Our ref: PL00088303 &  
PL00541702

Your ref: EN010077 &  
EN010078

Planning Act 2008, Scottish Power Renewables, Proposed East Anglia One North (EA1N)  
and Two (EA2) Offshore Windfarms

Historic England response to ExQs 3: Question 3.8.4

**CHVP3 – ProW between Moor Farm and
Little Moor Farm (Appendix 24.7, Figure
8 – Update)**

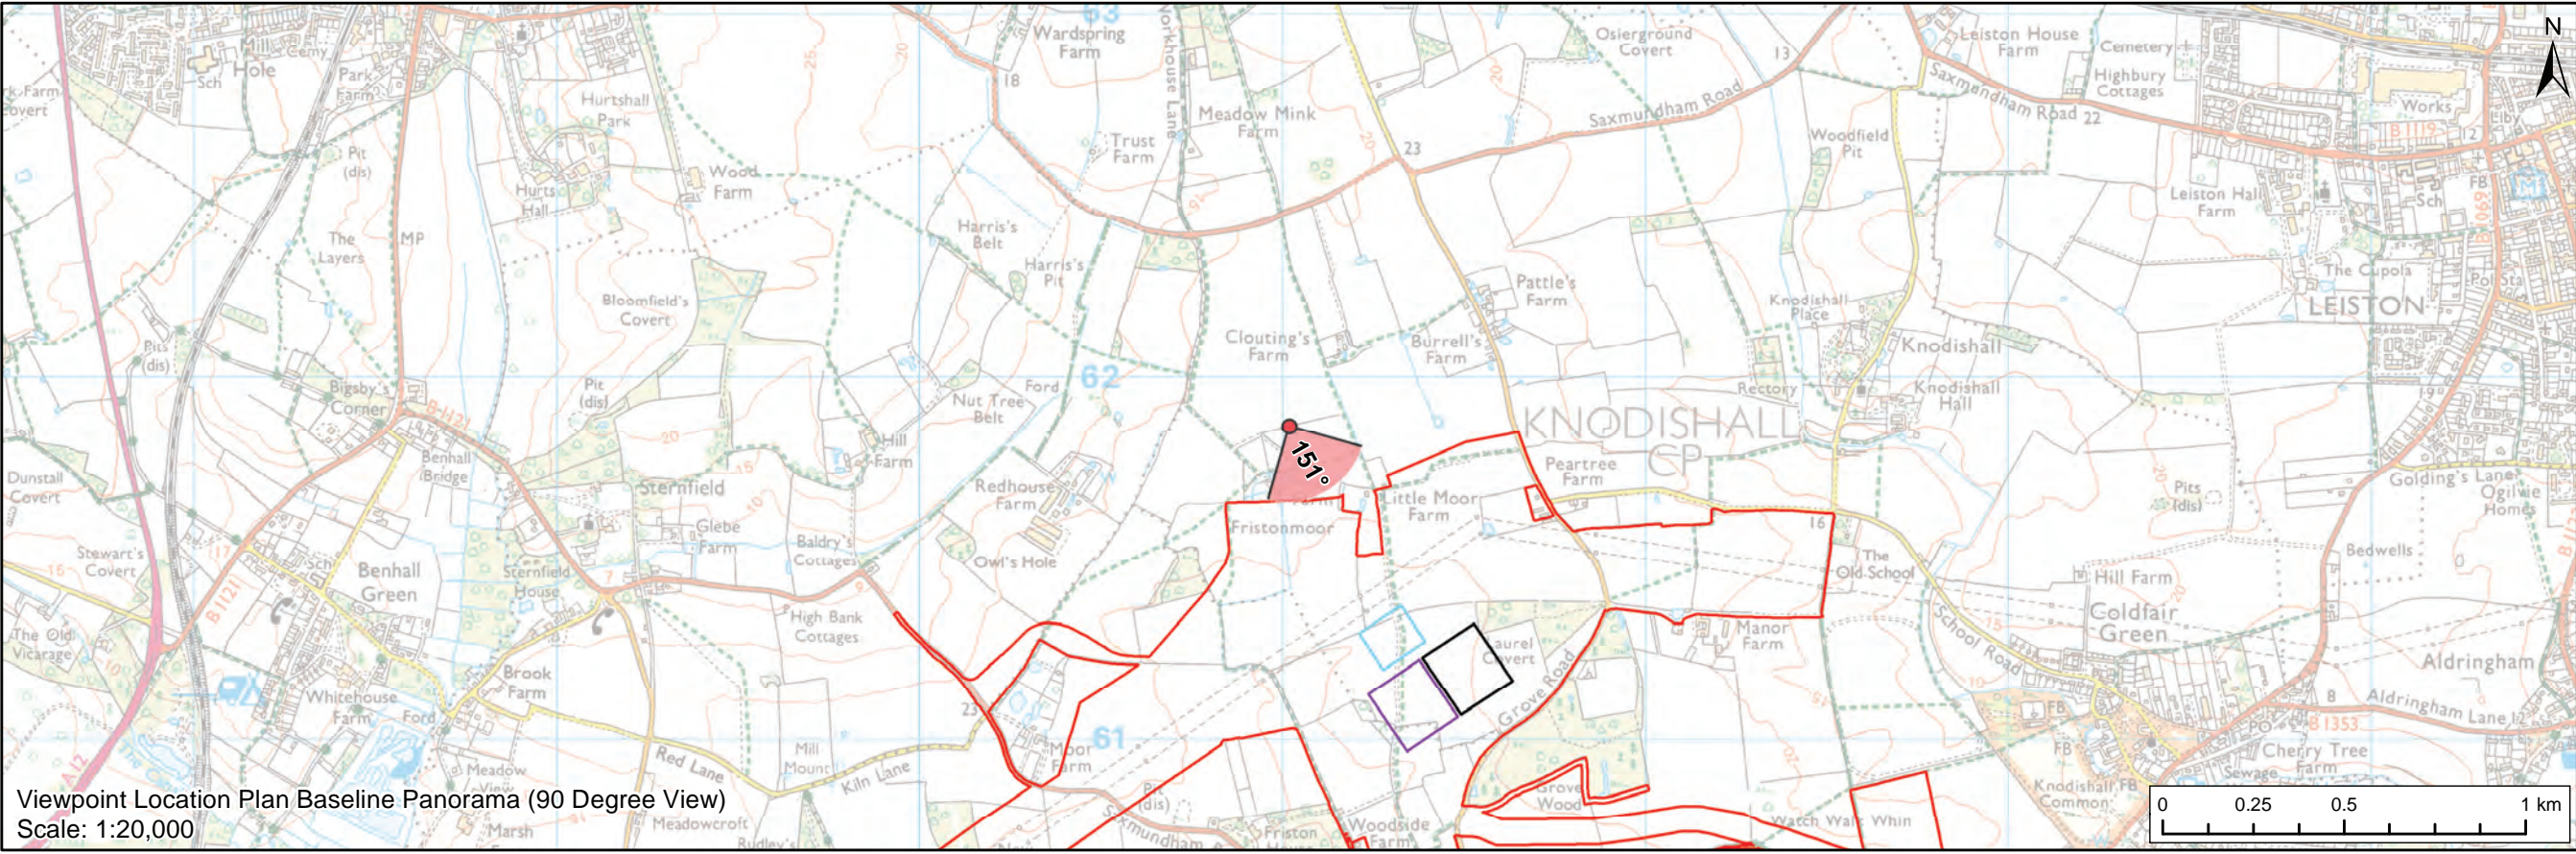
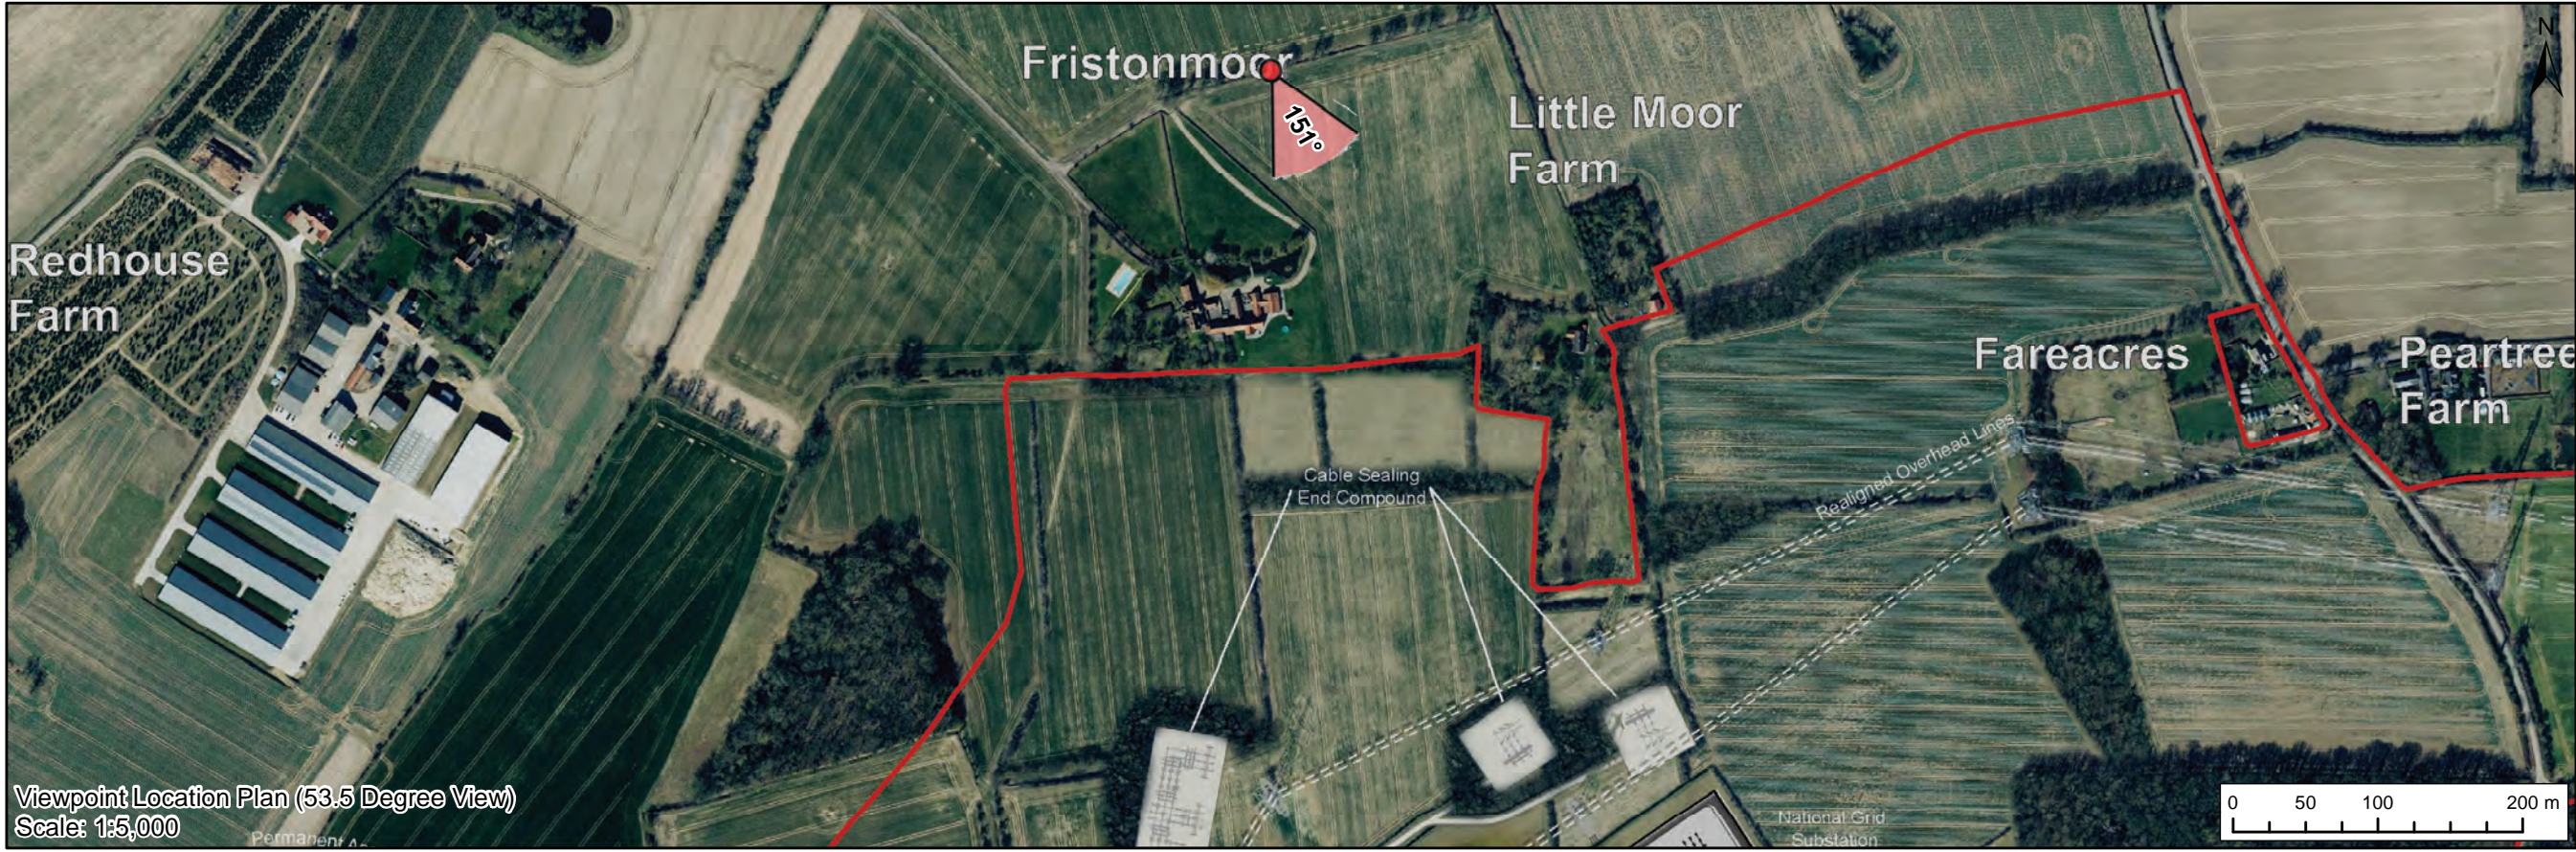
We have highlighted that one of the key views of the church is from the footpath associated with this boundary and track looking to the south. In our view the significance of the church is enhanced by how it is experienced in this landscape, and in particularly the views of the tower from the north and then views of the church when moving south from Little Moor Farm to the village. It is its presence as a key marker, a historical landmark and as the dominant building in

In terms of impact we have noted this elsewhere in previous letters, but the substation would be built across this boundary. It would sever it and remove an entire section. This would result in a direct physical impact upon the asset itself. We are conscious that the development would also erase the historical route between Little Moor Farm and Friston Moor and the village and would require a diversion of the right of way which has also survived along this boundary.

The scale and size of the development would deprive the church of its northern setting and would sever the relationship between the land to the north and the church. It would erode the rural context and remove any 'experience' of the church from the land to the north, and from this historic routeway and footpath. We have also set out this issue in previous advice.

We have reassessed this in light of the question set out above and concluded this development would result in a severe harm to the non designated asset and we remain of the view that it would result in very high degree of harm to the designated church. Our position remains unchanged, although we acknowledge that a greater understanding of the boundary does contribute more to our understanding and experience of the church and increases the contribution this land makes to the church's significance.
